Our Ref: BR/157/13/

**Town & Country Planning Act 1990 (as amended)
Town and Country Planning (Development Management Procedure) (England) Order 2010 (as amended)
Application for Full Planning Permission**

Development Proposed french doors with glass juliet balcony with glass balustrade
Location 6 The Gables Norfolk Square Bognor Regis

sheet 1 a of 2

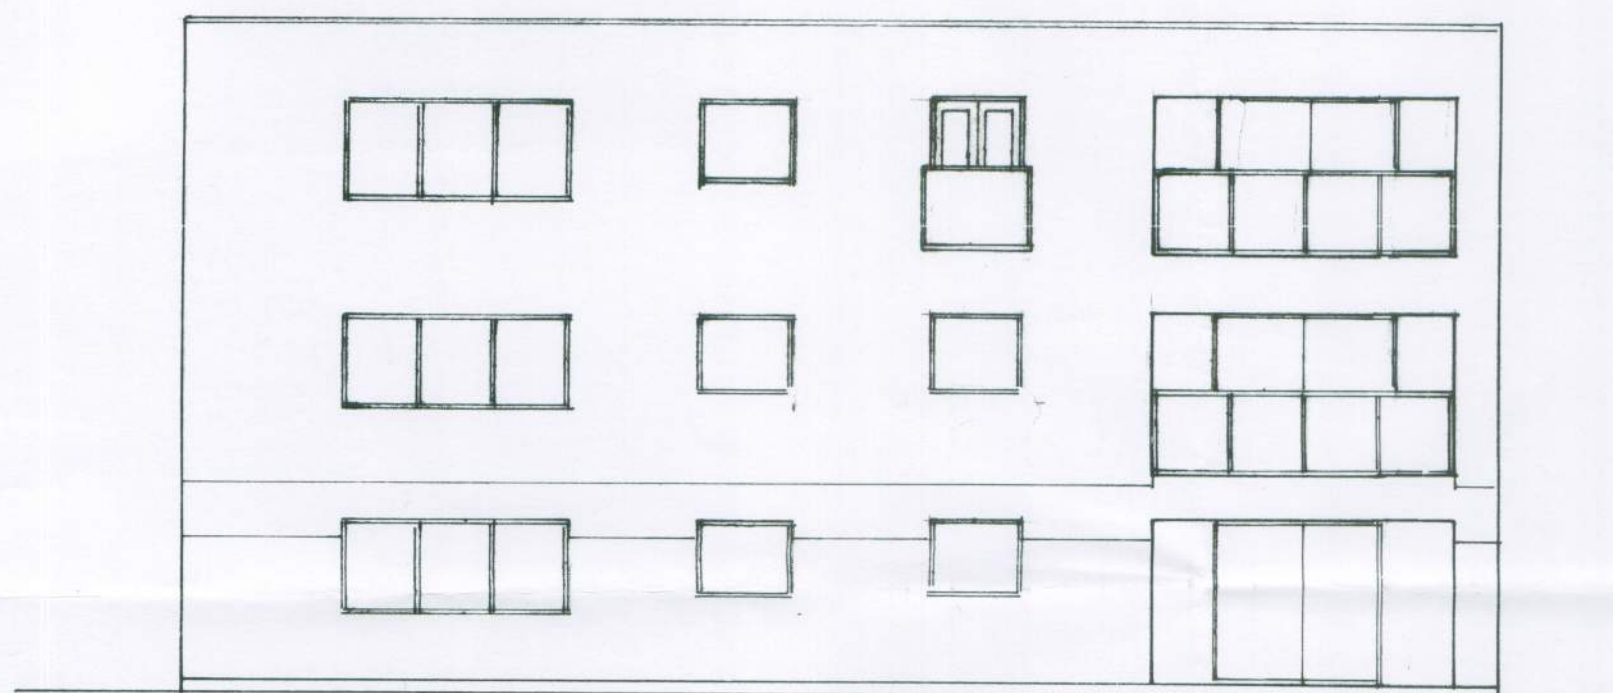
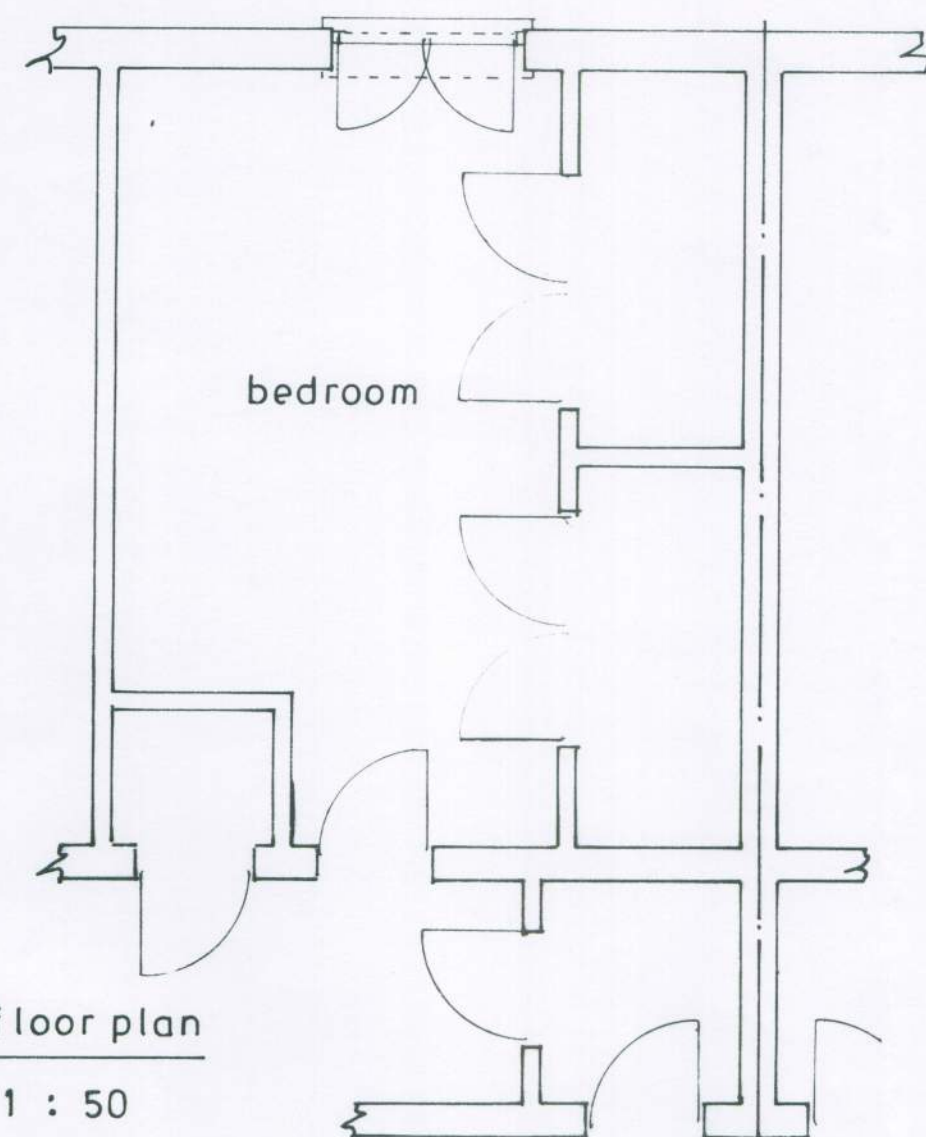
Please provide the specification or manufacturers details of the exact glass balustrade proposed.

block plan

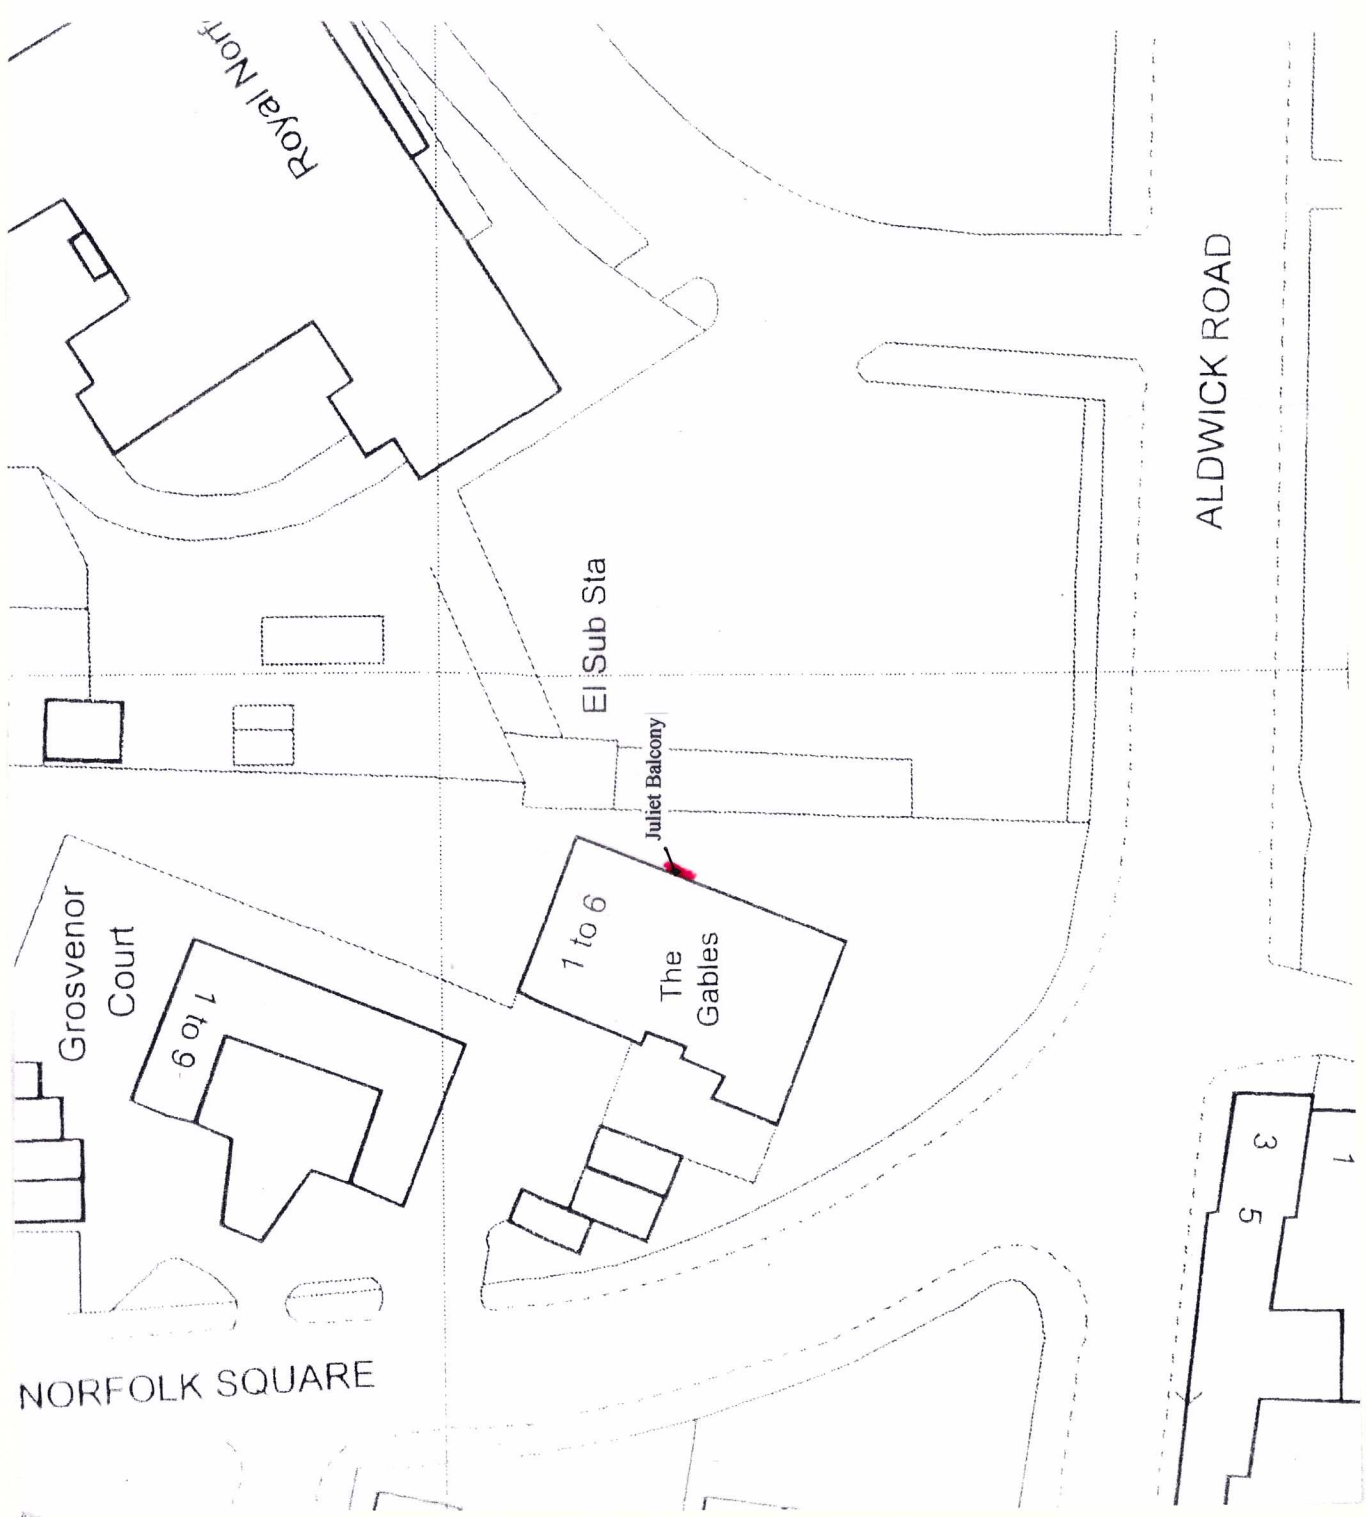
Block Plan

Please submit 1 electronic or 3 paper copies of a revised block/site plan with the proposed balcony clearly indicated at a scale of 1:500 or 1:200. Further details of what must be included on the plan can be found in the National Validation Requirements.
